Transport
for NSW

PCU012764

**DUBBO BASE HOSPITAL REDEVELOPMENT
STAGE 1 AND 2 (SSD 5250-2012)**

Client Health Infrastructure				
Dubbo Base Hospital Redevelopment Bus 12.5m Swept Path Analysis		Status NOT FOR CONSTRUCTION Date 19/12/12 Datum Scale NTS Size - Drawing Number 01234/B/01 Revision REV

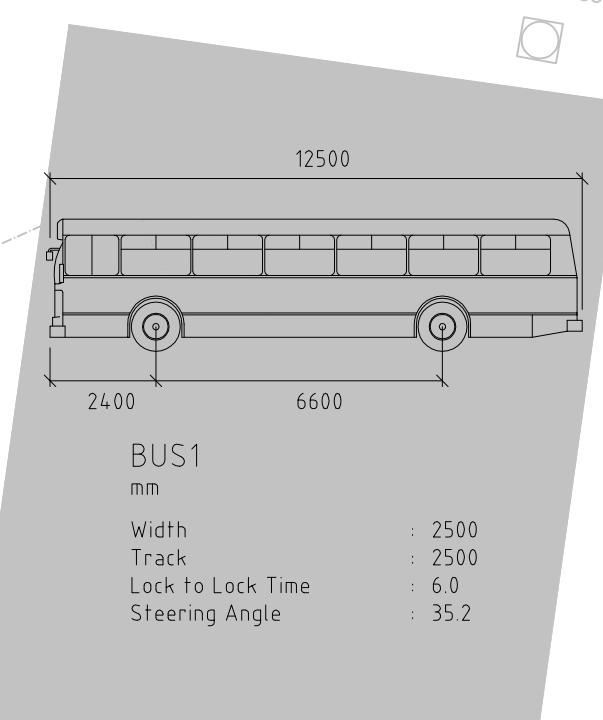
TfNSW encourages collaboration between Health Infrastructure and Dubbo City Council to facilitate appropriate intersection works the alteration of the internal roadways to cater for buses entering the hospital site and turning on site.

Transport for NSW considers the proposed redevelopment of the hospital to be an excellent opportunity for the alteration of the configuration of internal roadways within the hospital site and suggests that the proposal be amended to include an internal road network that ensures buses have the opportunity to enter the hospital site and turn on site as displayed in **Attachment 1**.

In addition to the above a sheltered accessible bus stop could be provided on the hospital's designated bus service roads. This should be in the immediate vicinity of the entrance of the main hospital building, helping to minimise walking distances for hospital patients, staff and visitors. The bus stop could also be designed to accommodate community transport services including community transport buses and cars. Designated bus service roads within the hospital site and intersections and round-a-bouts on bus service roads should be designed to adequately and safely accommodate bus manoeuvrability.
